WELWYN HATFIELD BOROUGH COUNCIL  
DEVELOPMENT MANAGEMENT COMMITTEE – 5 DECEMBER 2013  
REPORT OF THE DIRECTOR (STRATEGY AND DEVELOPMENT)

S6/2013/1338/FP

68 WALKER GROVE, HATFIELD, AL10 9PL

CHANGE OF USE FROM A DWELLINGHOUSE (USE CLASS C3) TO A HOUSE IN  
MULTIPLE OCCUPATION (USE CLASS C4)

BLOCK PLAN
AREA 90m x 90m
SCALE: 1:500 on A4
CENTRE COORDINATES: 520762 , 208967

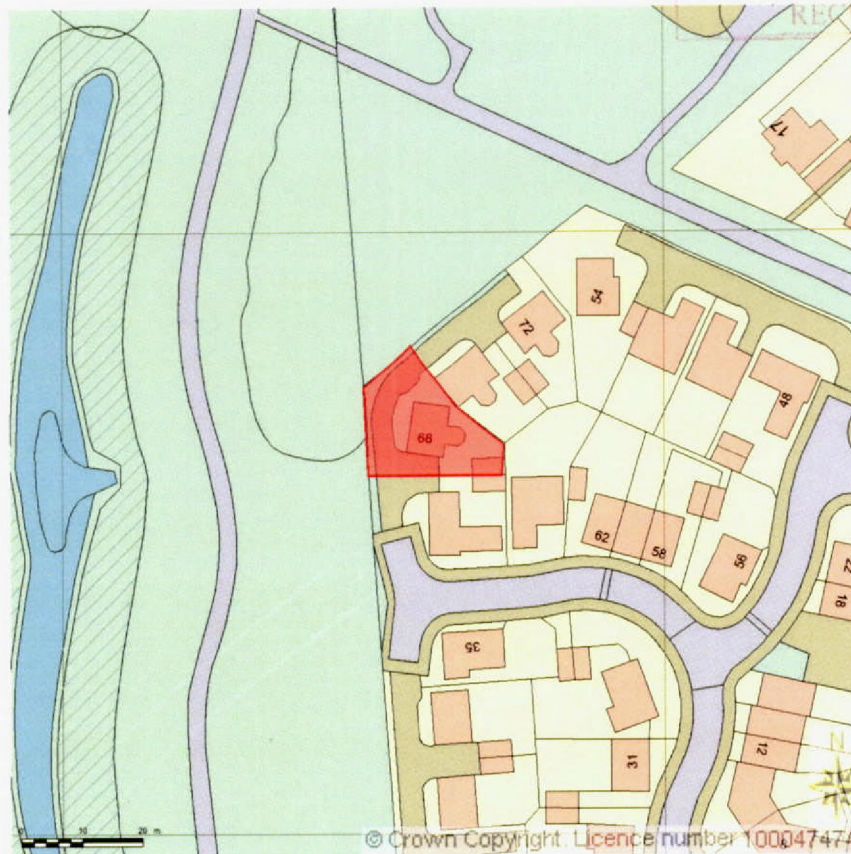
11.17 The car parking requirement for a six bedroom HMO is three parking spaces to be provided within the curtilage of the application site. The submitted application form states that there are four parking spaces, however, their location has not been identified on the Block Plan. Notwithstanding this, it was clear from the site visit that there are three off street parking spaces in addition to one garage space. Two spaces are situated in front of the garage, whilst a single parking space is provided by a lay-by (dedicated to No.68) towards the north west of the application site.

11.18 Criterion HMO2 of the HMO SPD states that all parking spaces should be capable of being used independently of one another. Whilst it is acknowledged that of the four parking spaces available at the application

property, only two spaces could be used independently (the lay-by and one of the spaces in front of the garage), this is insufficient grounds on its own to justify refusal of planning permission. Moreover, criterion HMO2 states that regard will also be had to the existing parking situation in the area. In this case, there is no substantive evidence to demonstrate that there is any significant pressure for car parking in the area of the site. In this regard it is relevant that there are a considerable number of private garages nearby, as well as off-street parking spaces, and there are very few parking restrictions on the roads. Furthermore, on street parking appeared to be controlled by permits, which should ensure that it is available for use by local residents.

Ground Floor Plan - Proposed

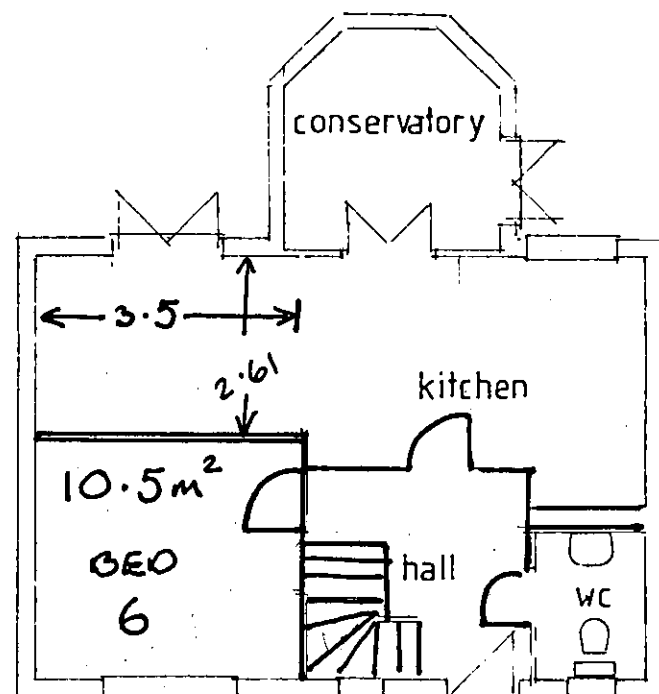
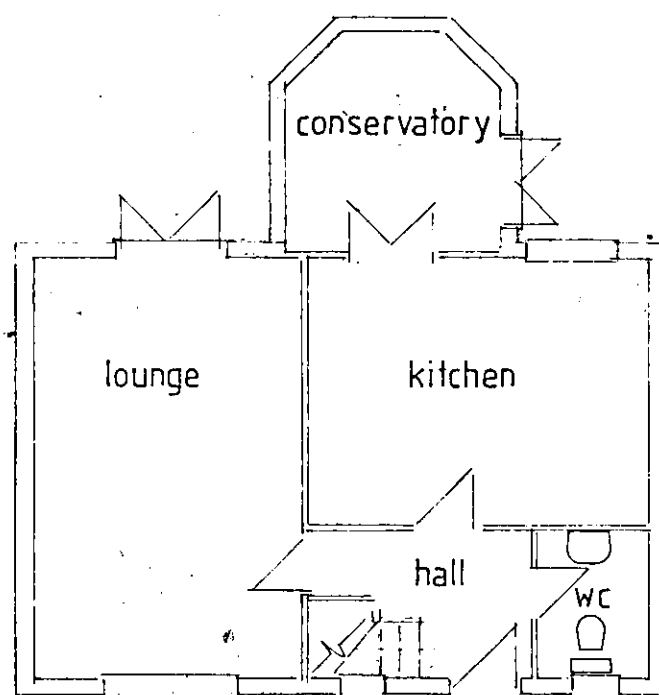
- 2.1 This application seeks full planning permission for the change of use from a five bedroom dwellinghouse (use class C3) to a six bedroom house in multiple occupation (use class C4). No external alterations are proposed to the application building. Internally it is proposed to partition the existing lounge to provide the additional bedroom and a larger kitchen/dining room.

11.15 The proposed layout would be acceptable in terms of the entrance which would open on to a hall as required by criterion HMO5 of the HMO SPD. Although there is not an allocated drying area within the plans, the rear garden is a sufficient size to accommodate an area for drying clothes. The garden area would exceed the minimum requirement of 23m<sup>2</sup> set out in the SPD, this area would be private and readily accessible to all occupants.

First Floor Plan
Existing/Proposed

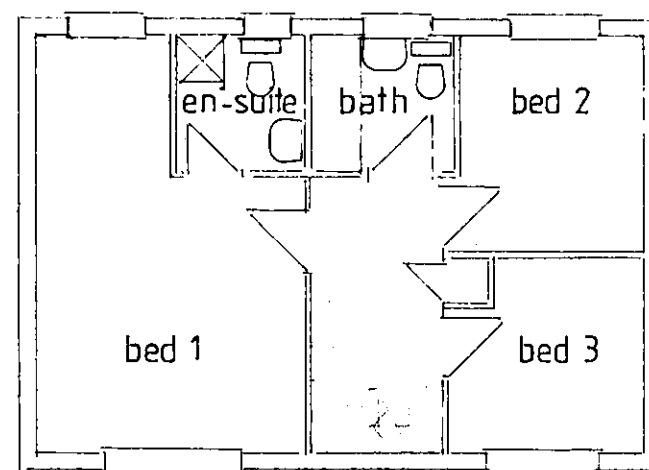
11.16 Bedroom 3 would be smaller than the minimum 8m<sup>2</sup> set out in the SPD, being approximately 6.5m<sup>2</sup>. However, the SPD is based upon the housing legislation for room sizes (as set out at Appendix 2) and the housing legislation provides for more flexibility, which is considered relevant in this particular case. Firstly, where adequate communal areas exist the bedroom standard can be reduced to 6.5m<sup>2</sup>. Although no separate living room is provided at the application dwelling, the communal facilities are generous and include a large kitchen/diner and a conservatory. The kitchen/diner measures approximately 22.2m<sup>2</sup> which comfortably exceeds the minimum space required of 12.5m<sup>2</sup> and is sufficient to provide kitchen facilities as well as a dining table that would seat all six occupants at once. It is considered that the dwelling as an HMO would comfortably accommodate six people in accordance with criterion HMO5 of the HMO SPD and the broad objectives designed to protect residential amenity in Local Plan Policy D1.
